Application for a Non-Material Amendment Following a Grant of Planning Permission

Erection of 3no. chalet bungalows with associated parking.

23/01318/FUL

Adjustment to detailing of dormer windows/ roof to accommodate technical design development and construction requirements.

Sheet title: Carnarvon Place - House Type A-A-A

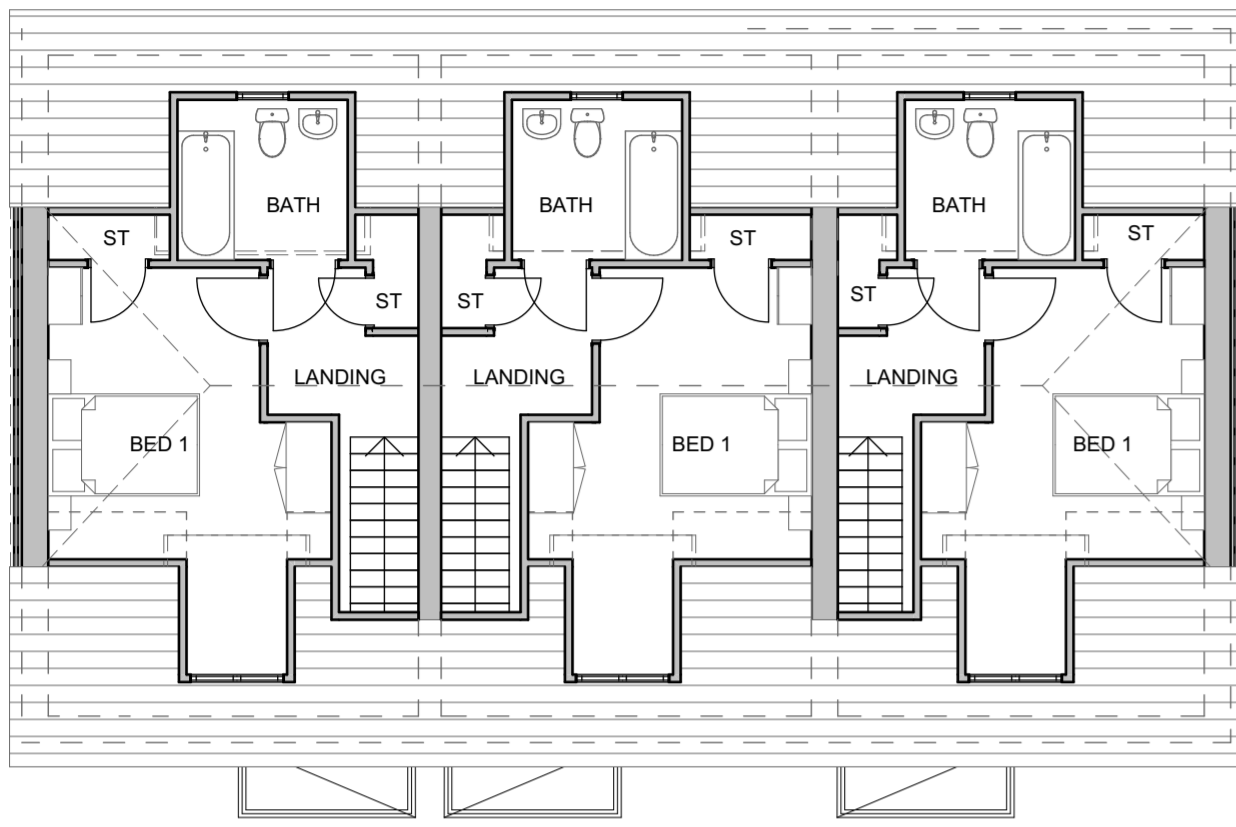
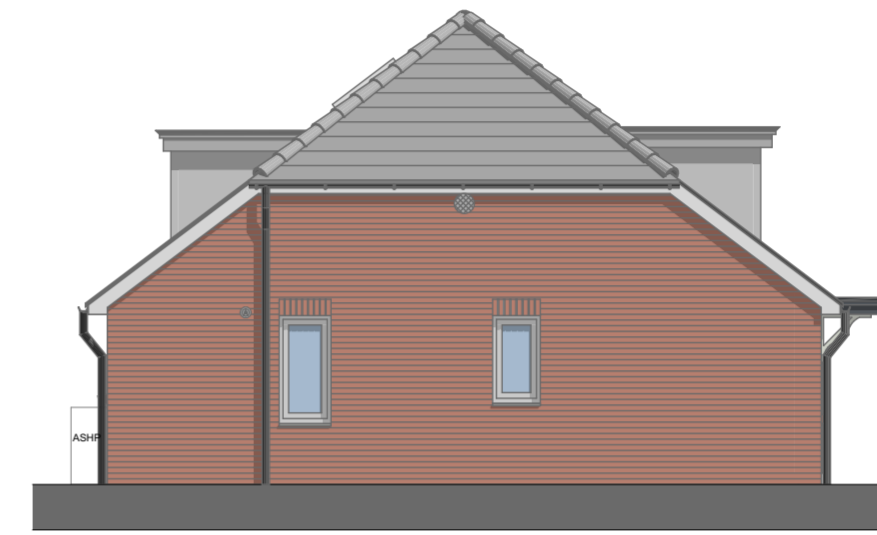
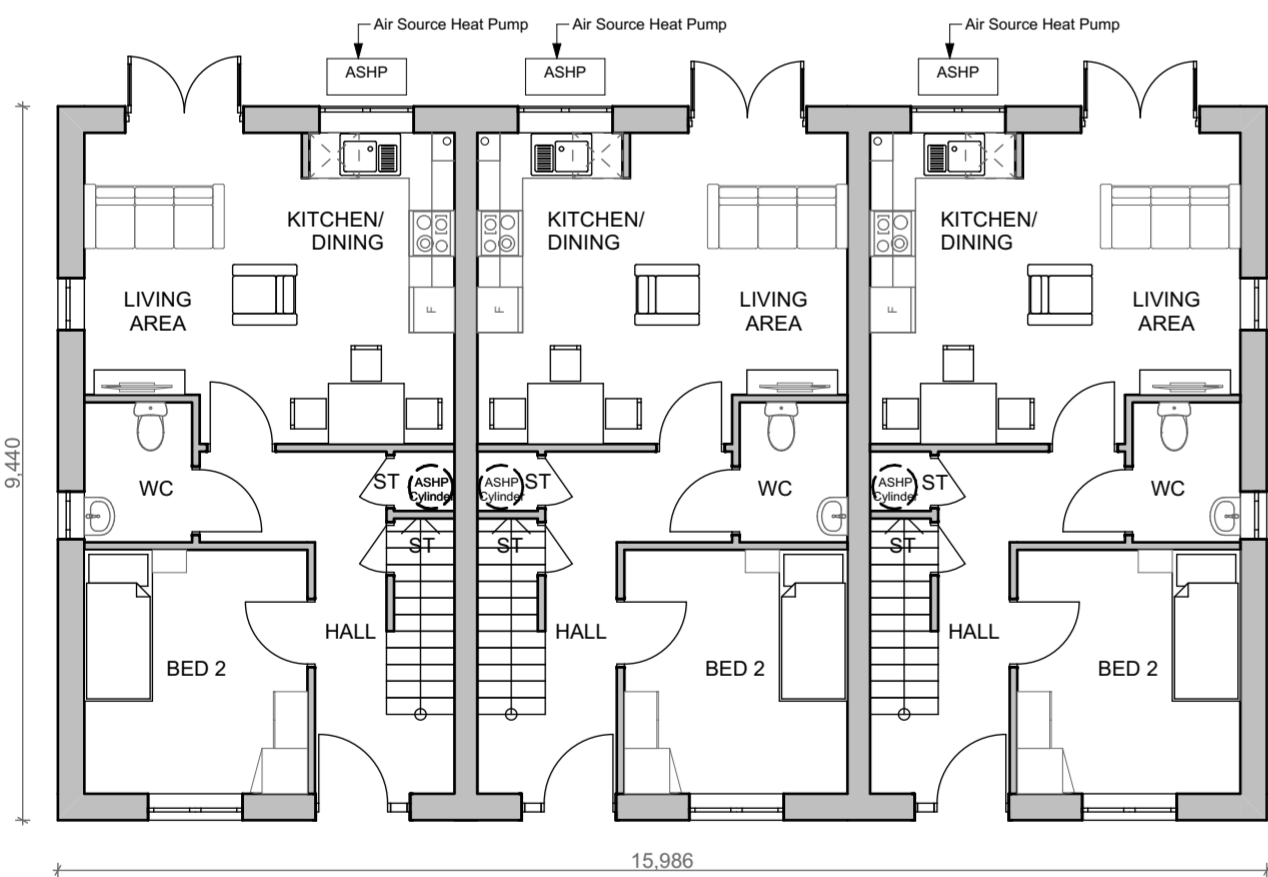
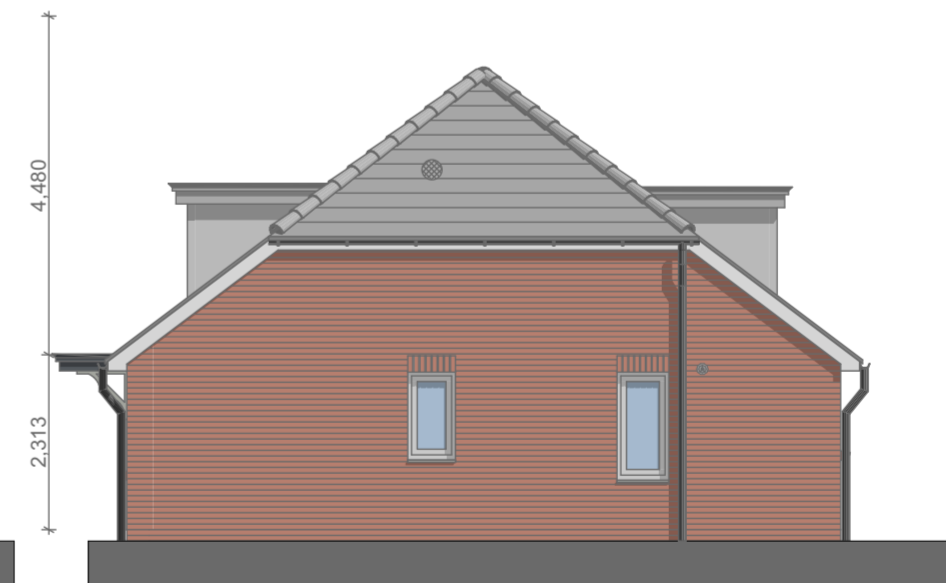
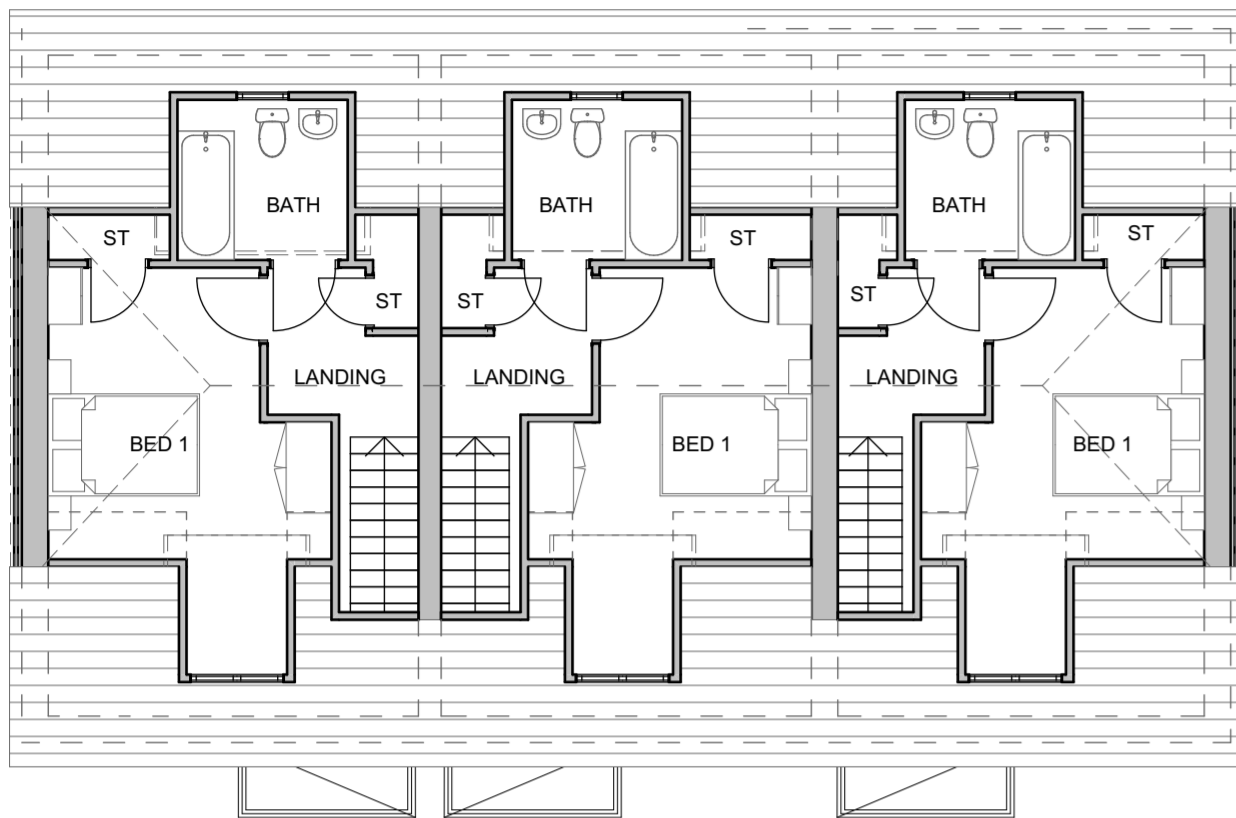
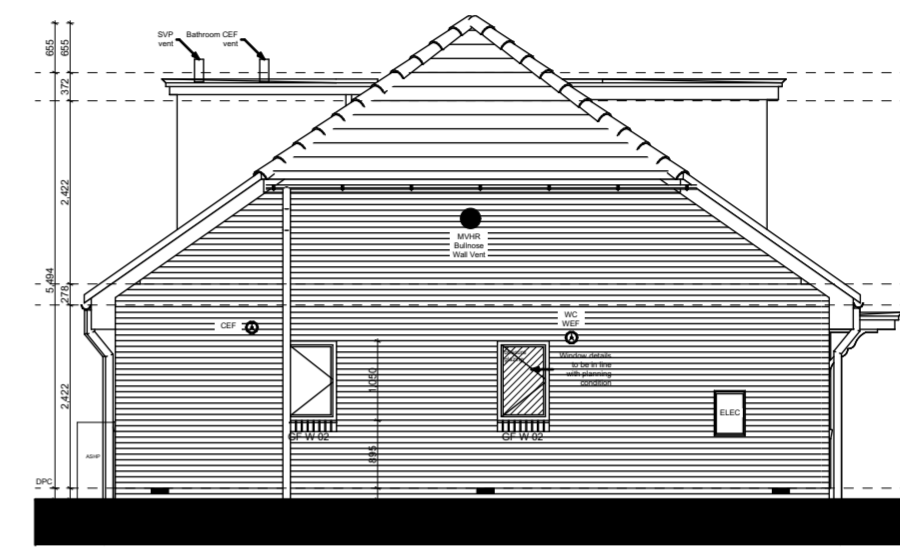
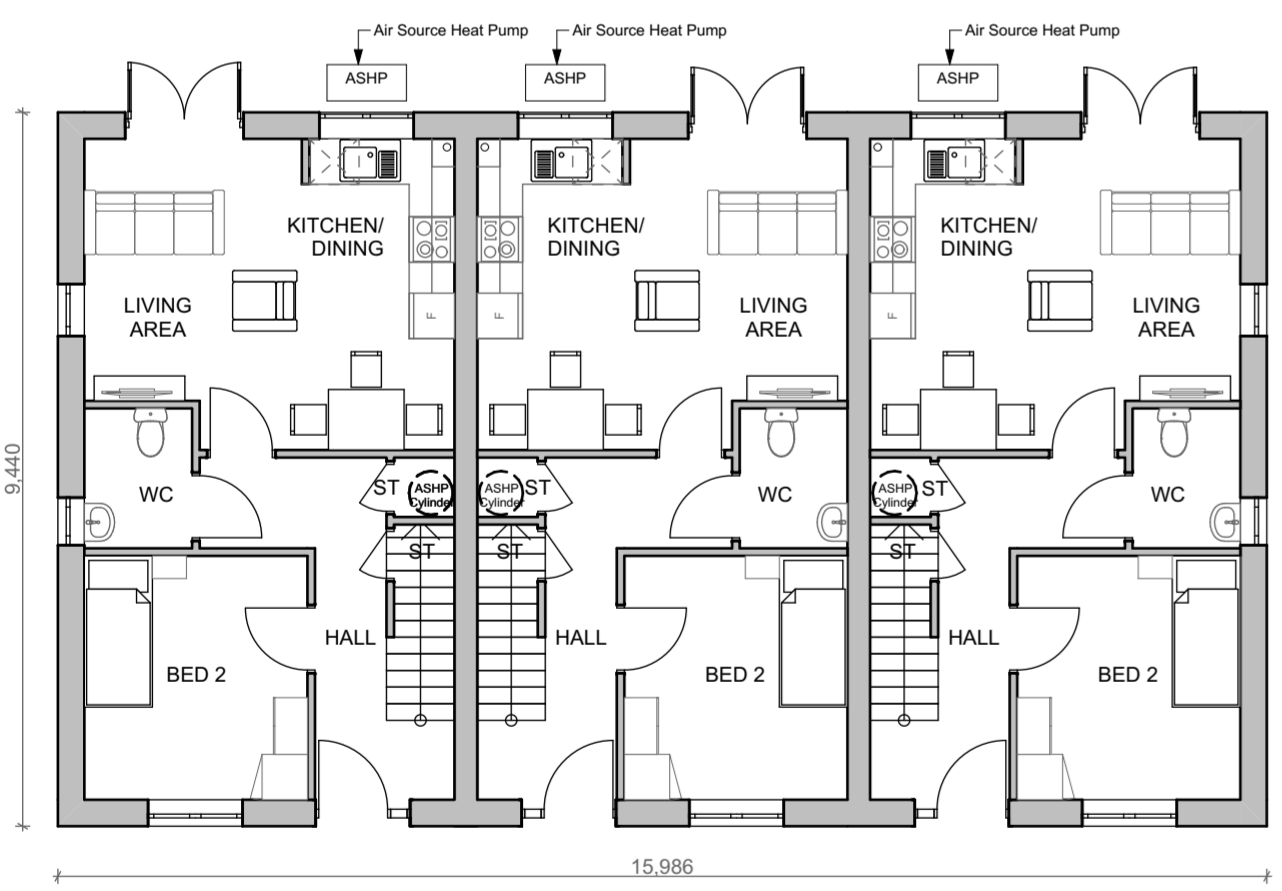
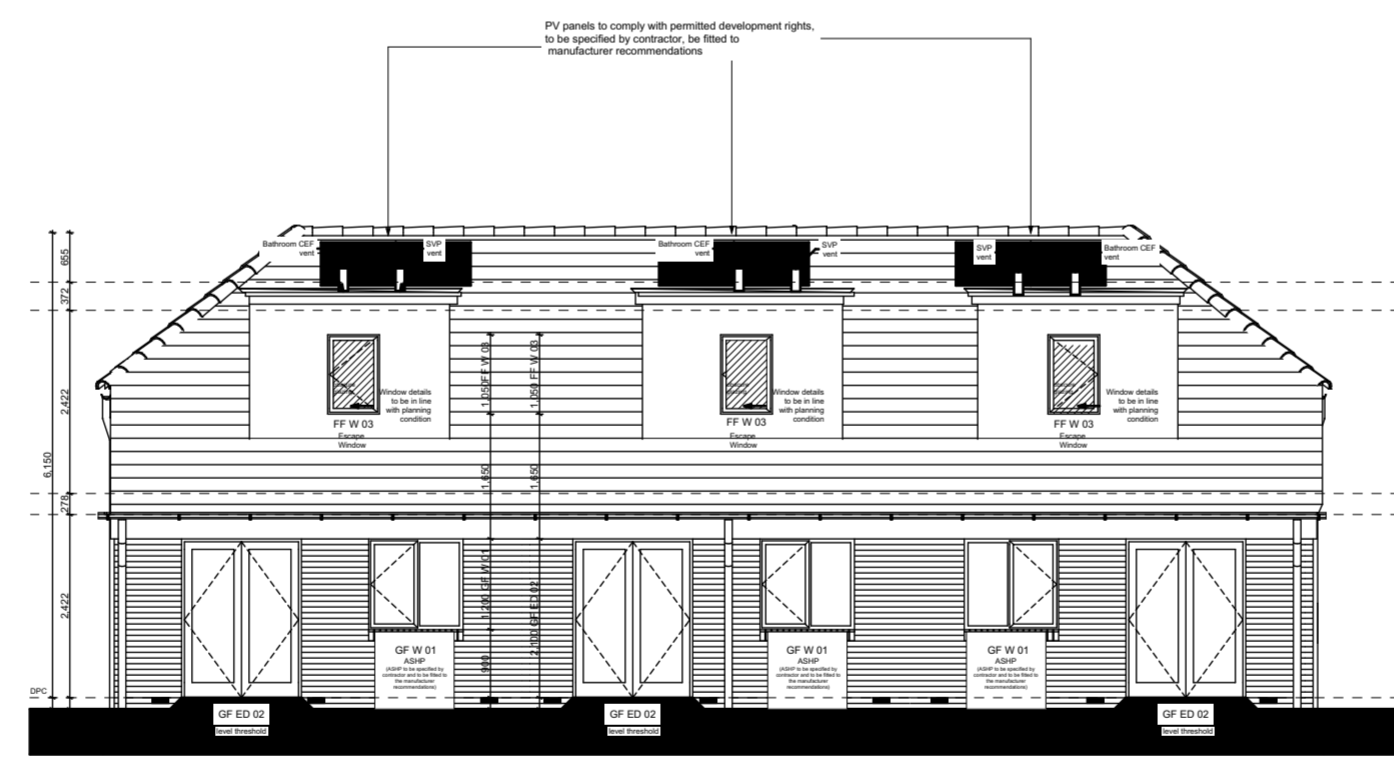
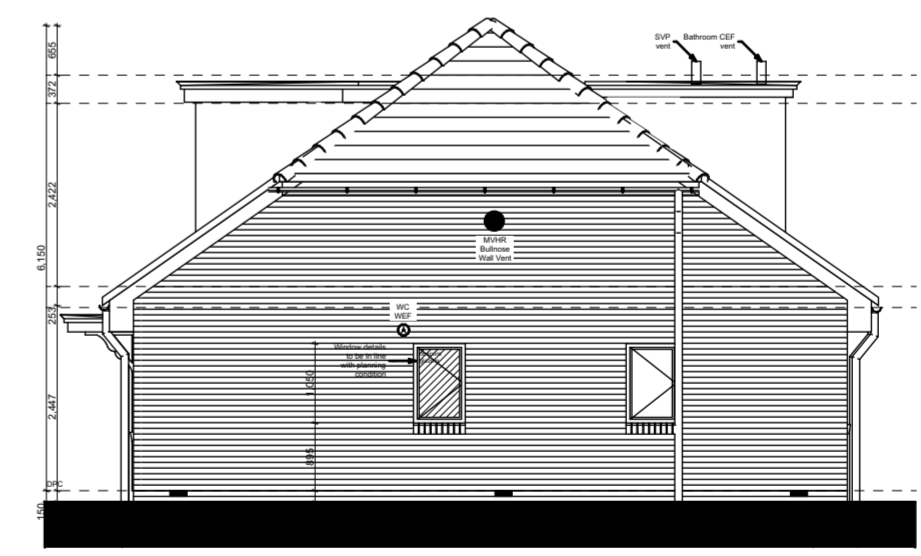
To accommodate technical design development and construction requirements.
